Rezoning Transportation Analysis

Petition Number: 2021-096

Date	Description
8-20-2021	First Review (DBS)
9-17-2021	Second Review (WB)
10-19-2021	Third Review (PDM)
11-22-2021	Fourth Review (AO)
12-29-2021	Fifth Review (PDM)

SHEET TITLE: TECHNICAL DATA
 SHEET NUMBER: RZ-1

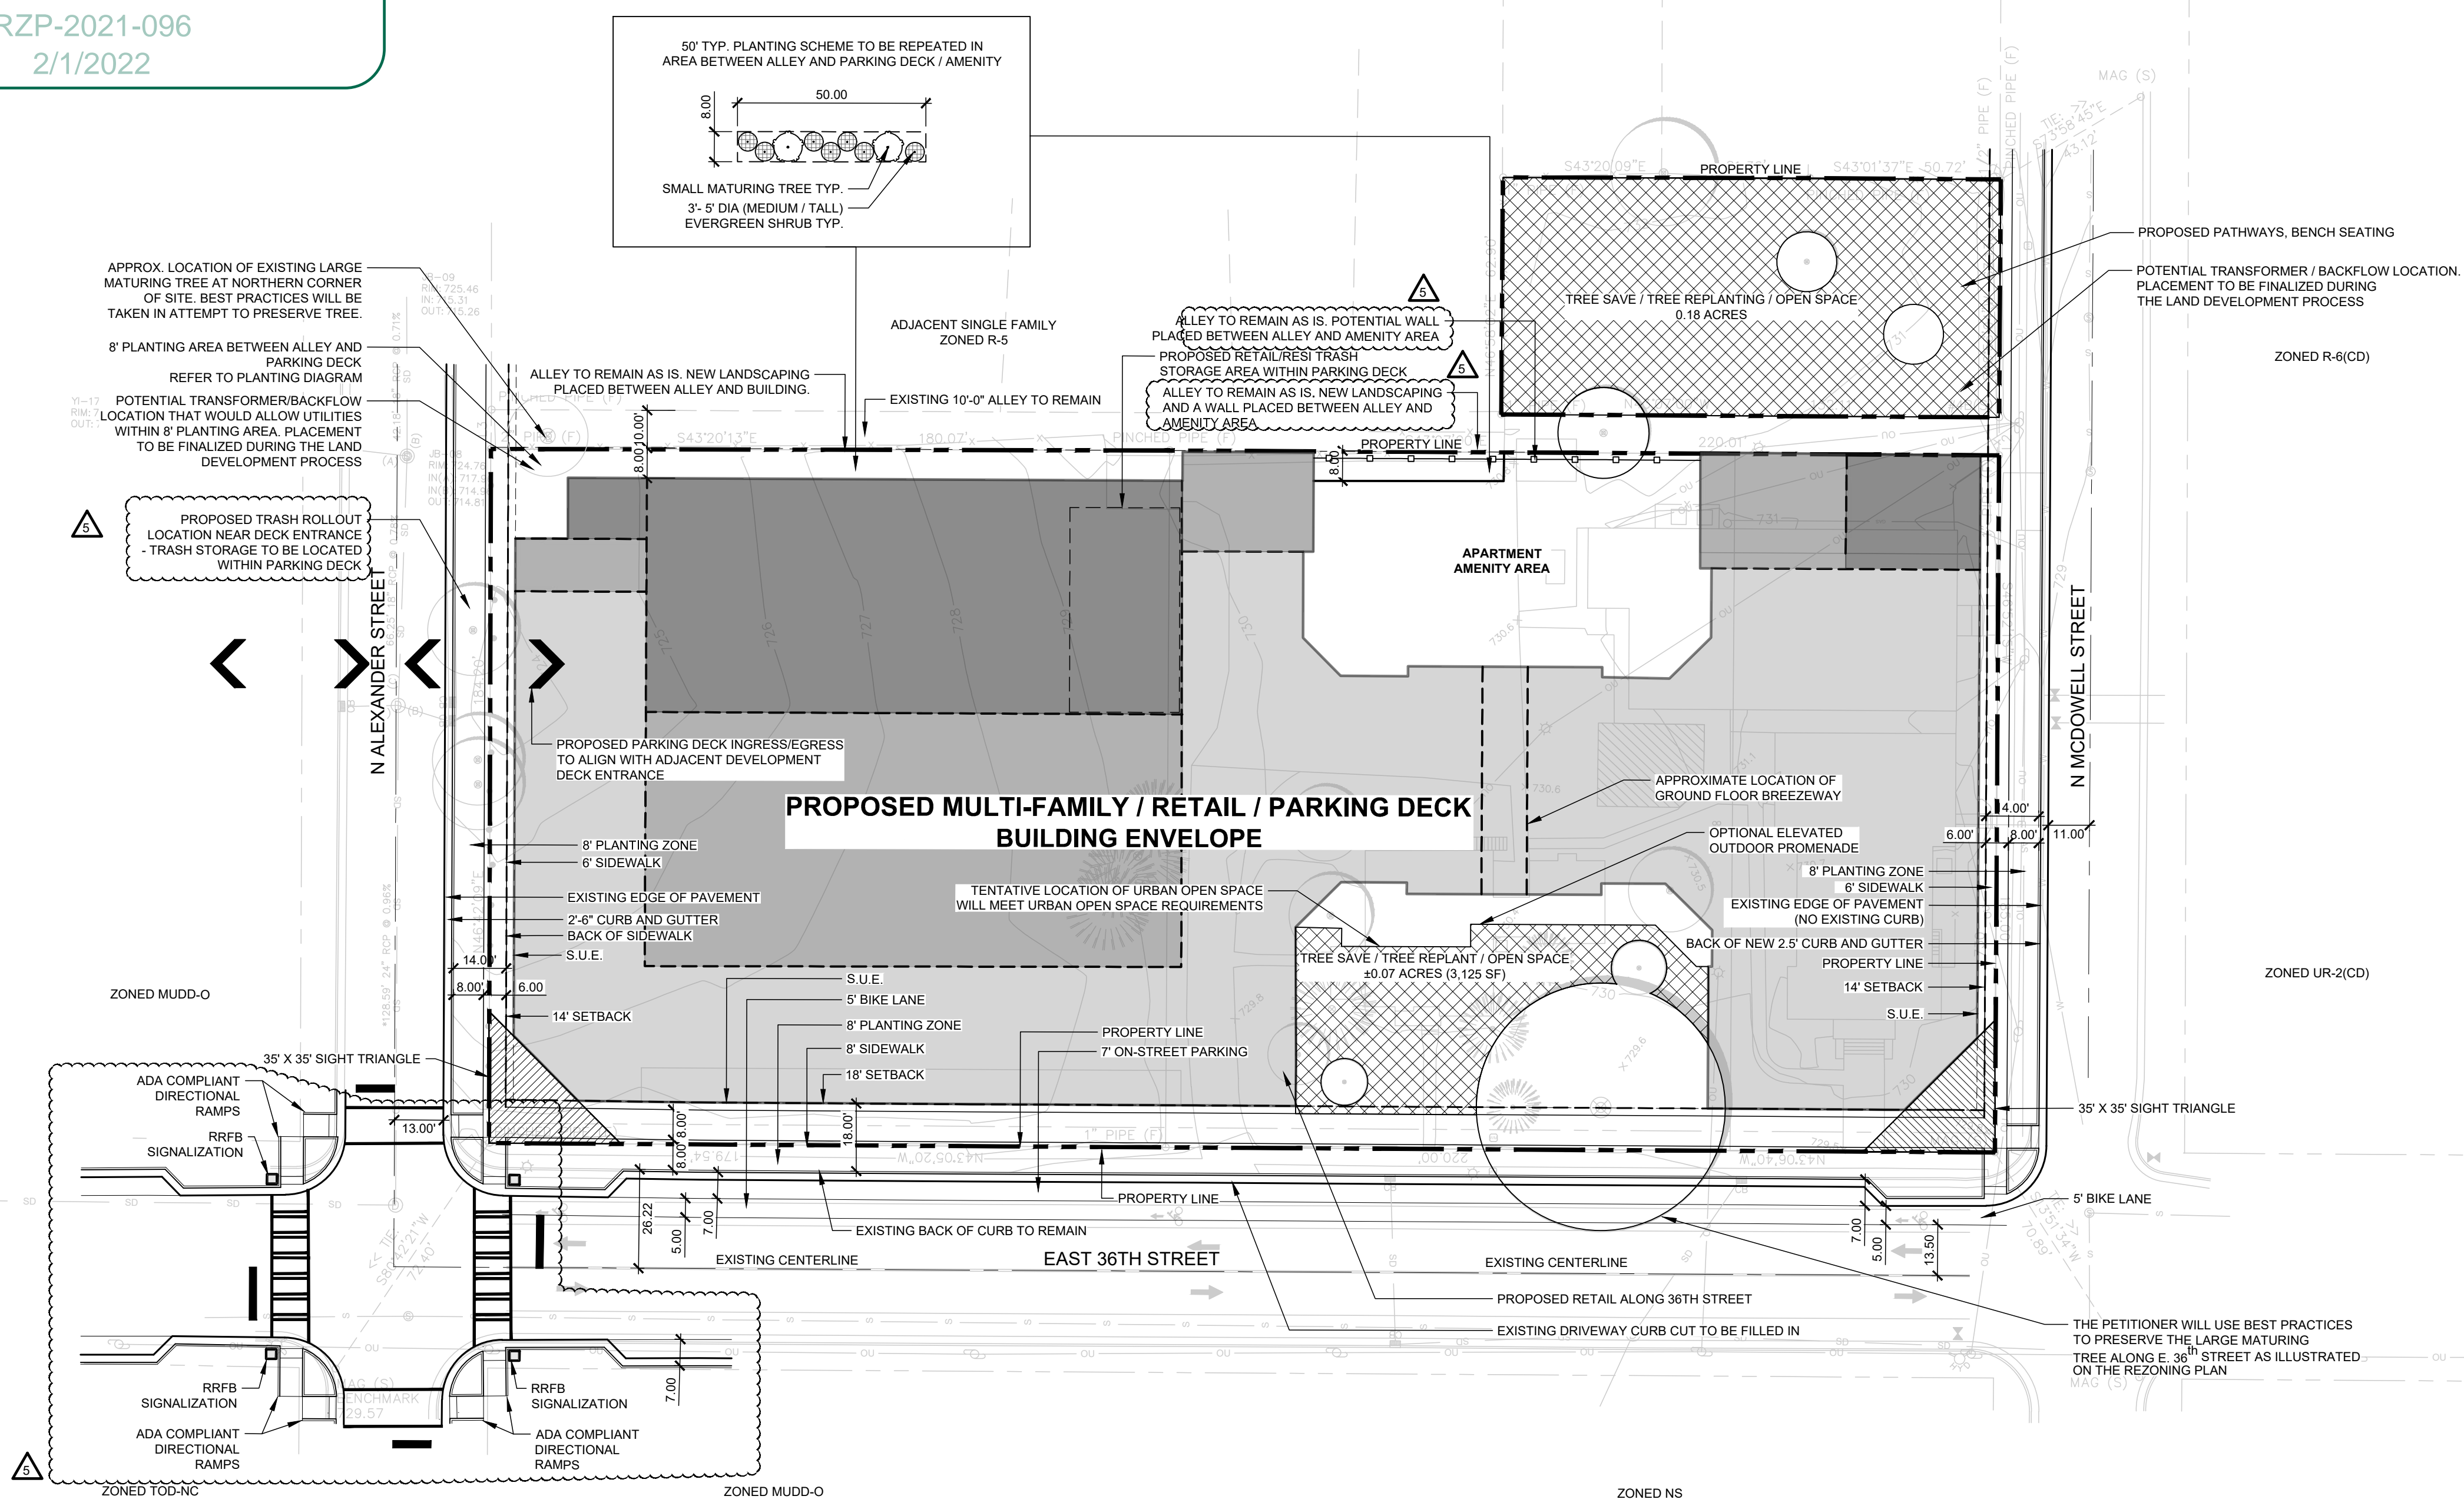
8. ~~Revise site plan to construct bulb-outs on East 36th Street at the corners of at North Alexander Street and North McDowell Street. Provide recessed on-street parking on North Alexander Street and North McDowell Street as SHOWN in the graphic below. New comment in response to request from Noda Neighborhood Board.~~

Outstanding Comment from 10-19-2021: Revise site plan to construct curb bulb-outs on all corners of East 36th Street and North Alexander Street.

9. ~~NEW COMMENT (10.19.2021)~~

~~Revise conditional notes to commit to installing a pedestrian crossing with a Rapid Rectangular Flashing Beacon across East 36th Street at Spencer Street. Final location of crossing to be coordinate and approved by CDOT during permitting.~~

SHEET NUMBER  
**RZ-1**

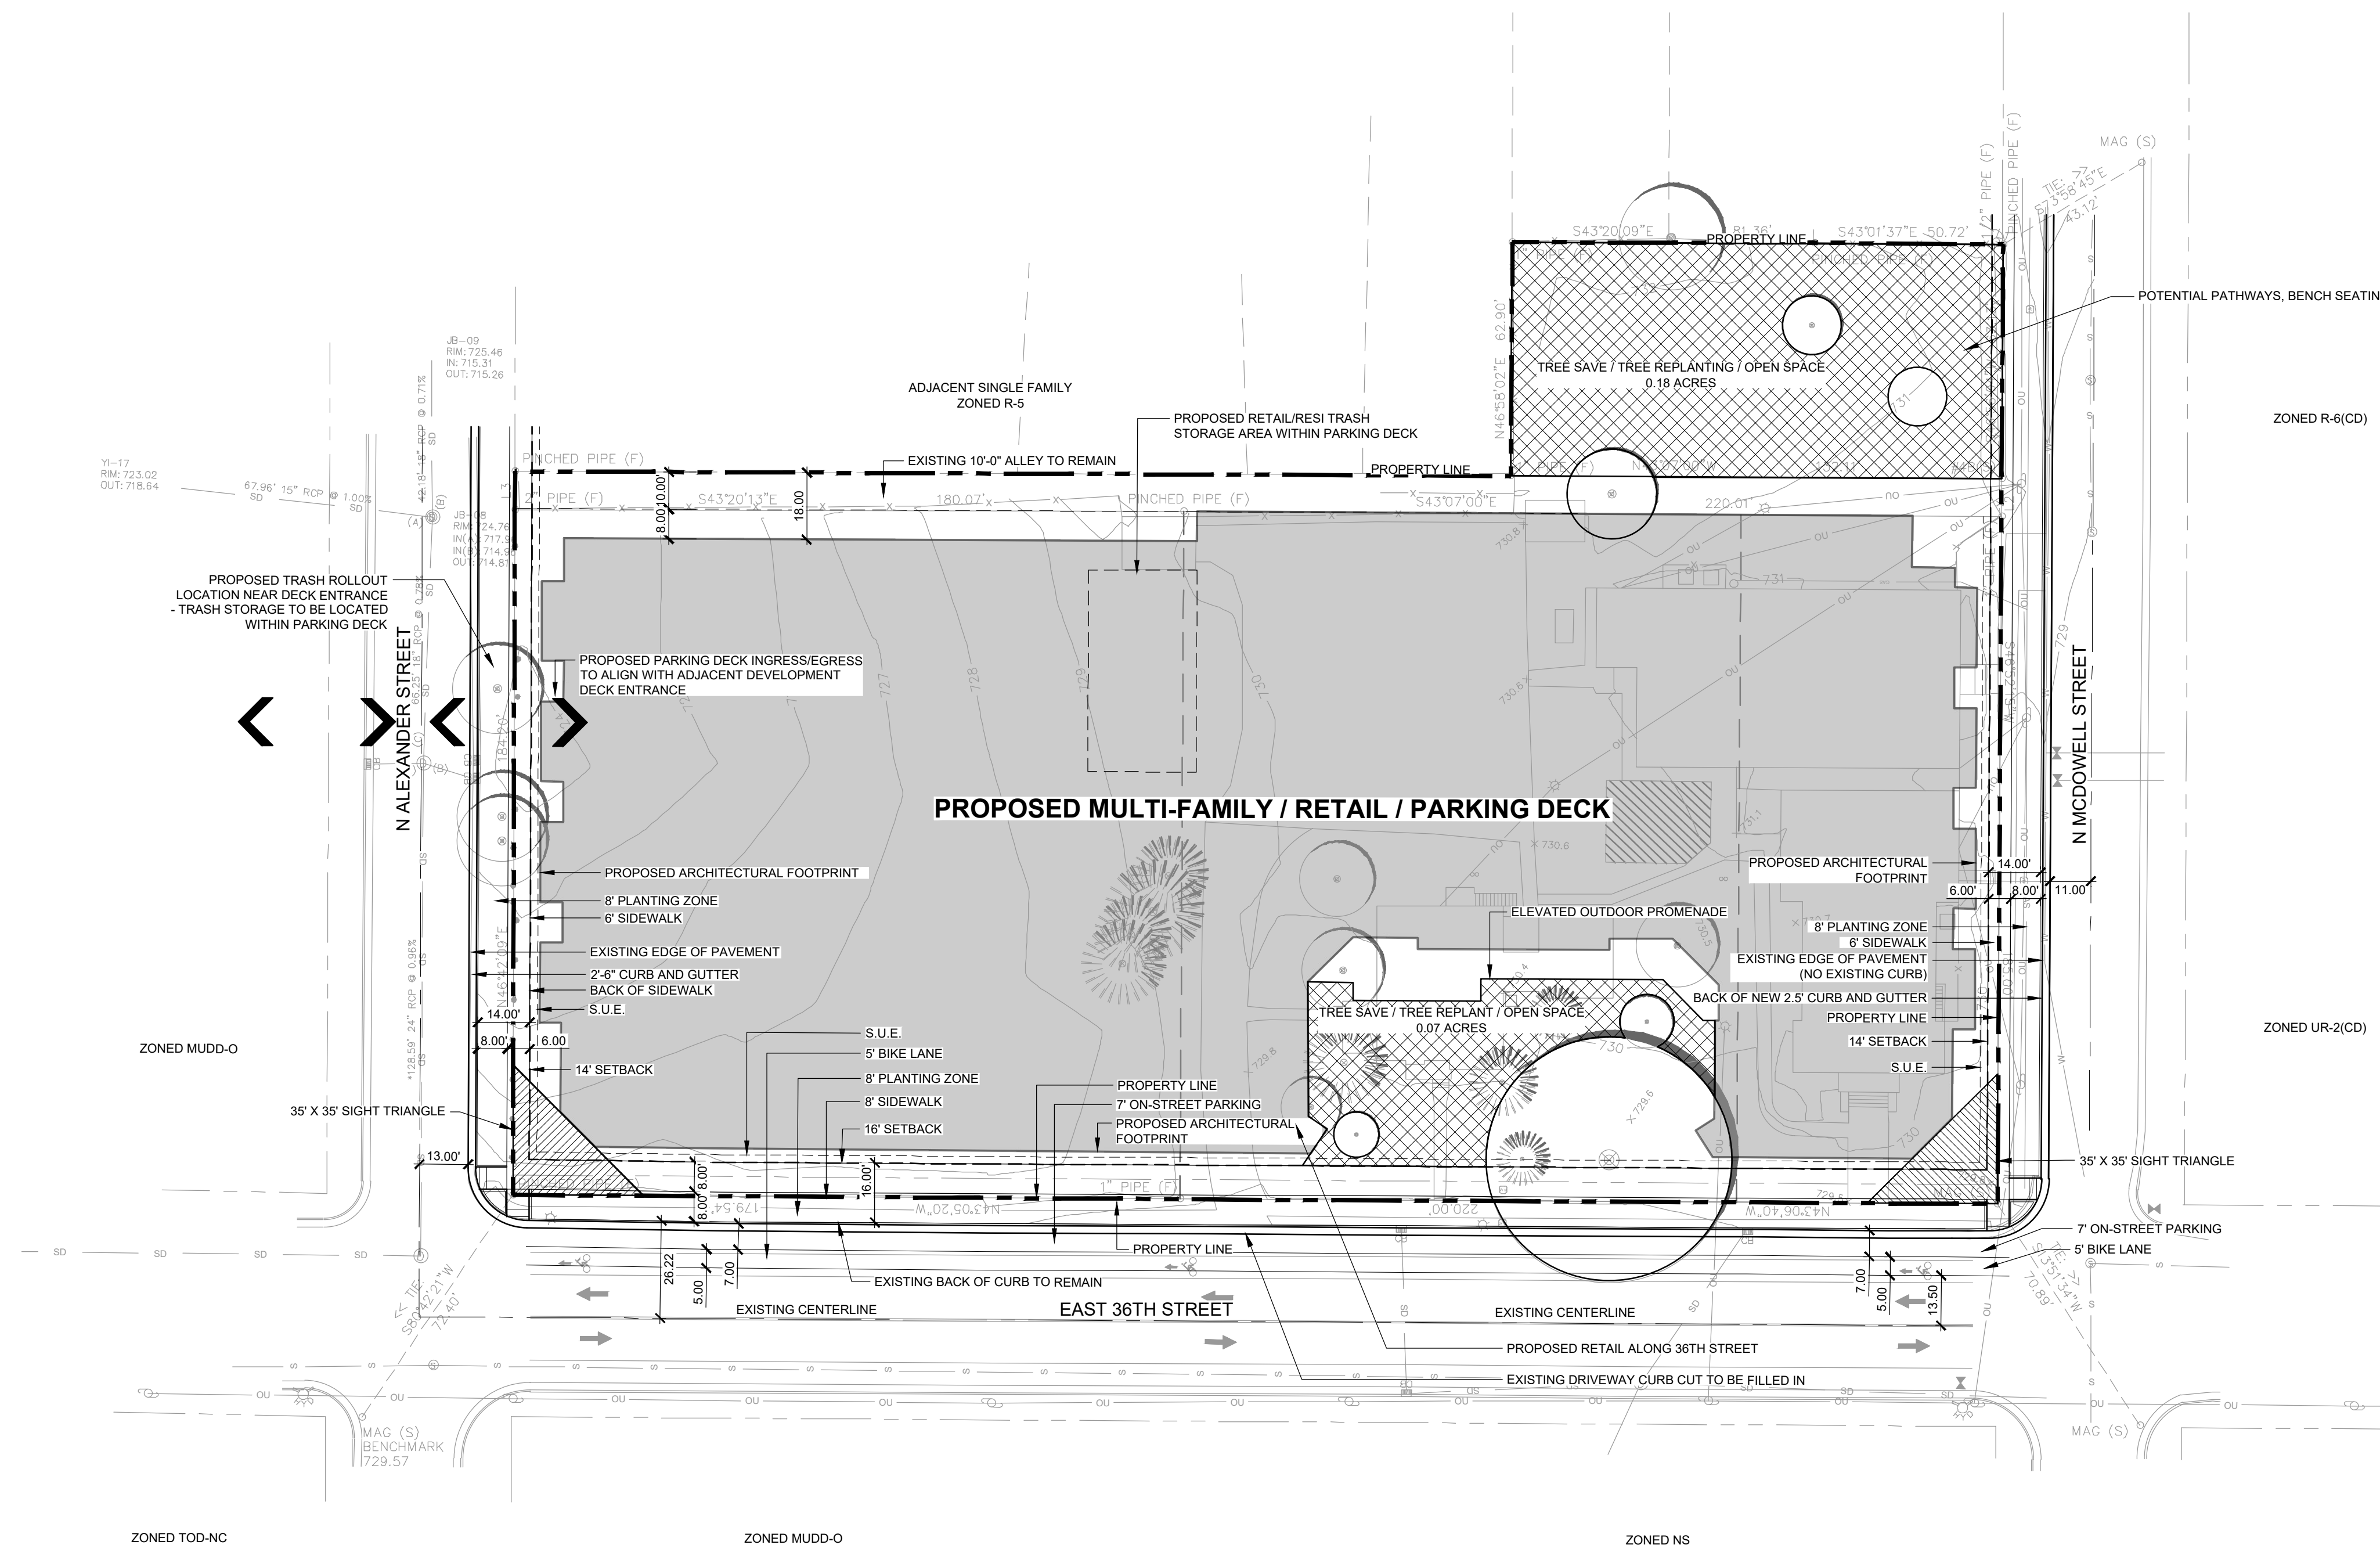
- ~~2. Revise site plan to reflect 10' x 10' sight triangles at the intersections of East 36th Street with North Alexander Street and North McDowell Street.~~

- ~~3. Revise site plan to indicate two curb ramps at the intersections of East 36th Street with North Alexander Street and North McDowell Street.~~
- ~~4. Revise site plan to indicate proposed access point(s).~~

- ~~5. Revise site plan to include dimensions of bike lane and on-street parking. Cross-section needs to be symmetrical from centerline street (bike lane and on-street parking on both sides)~~

- ~~6. The unused alley in the northwest corner of the site is for the benefit of all adjoining property owners and may not be planted unless it is formally abandoned.~~

- ~~7. Revise site plan to show replacing valley gutter on the North Alexander Street frontage with standard 2'6" curb and gutter to match the curb on the opposite side of North Alexander Street.~~
